Reference: H05-0855-19 **Date of Decision:** 7th November 2019

Location: Land Adjacent: Woolie Farm Langary Gate Road Gedney Hill

Description: Conversion of existing building to Class C3 residential use, including extension.

South Holland District Council hereby give notice that this application has been REFUSED for the above proposal for the following reason(s):

Drg No: LGRGH.PLAN 1

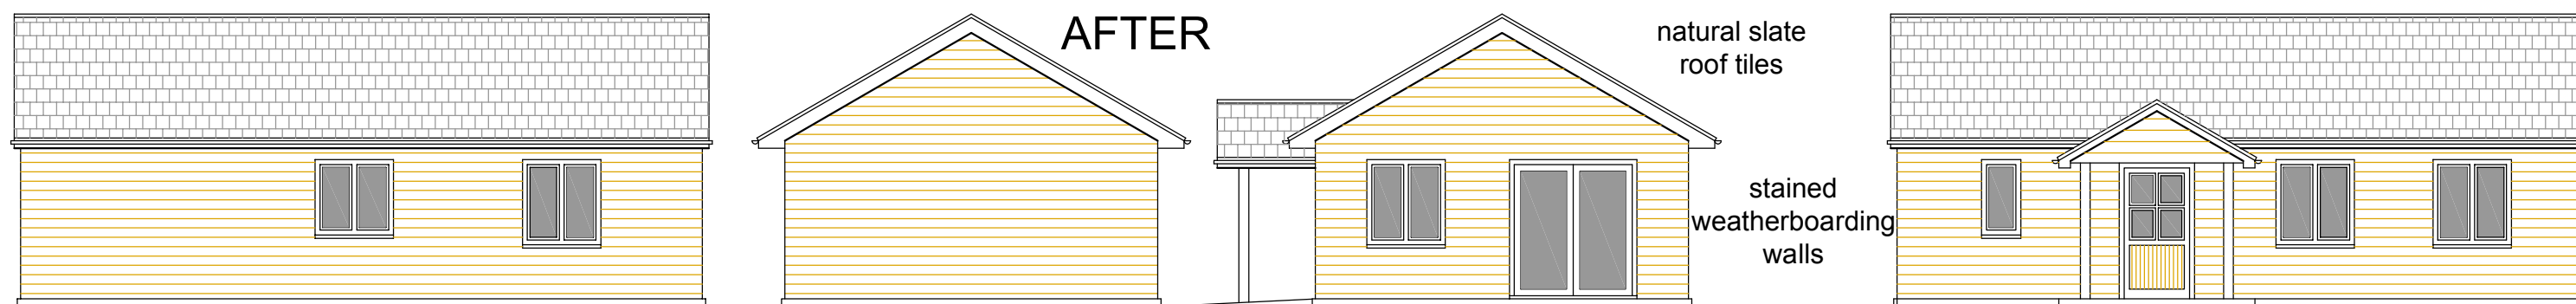
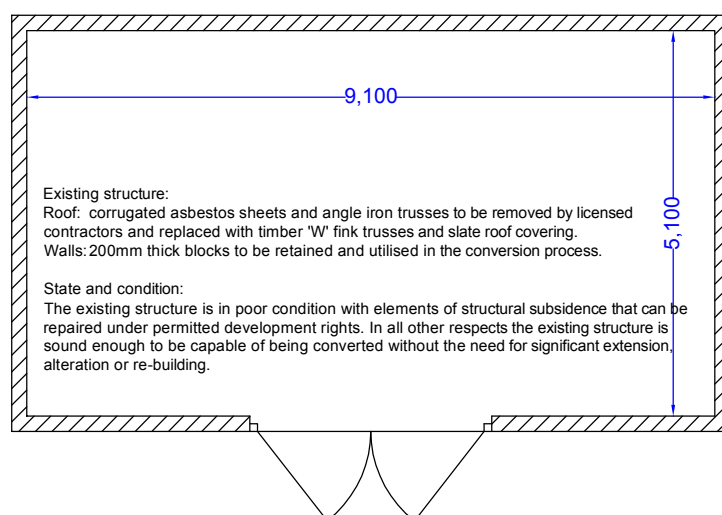
- 1 The building is of block construction with an asbestos/fibre cement roof. It is utilitarian in appearance and is not of architectural/historic merit. It is not worthy of retention on grounds that it makes a positive contribution to the character of the landscape. Consequently, the proposal is not in accordance with Policy 23 of the South East Lincolnshire Local Plan, 2019.
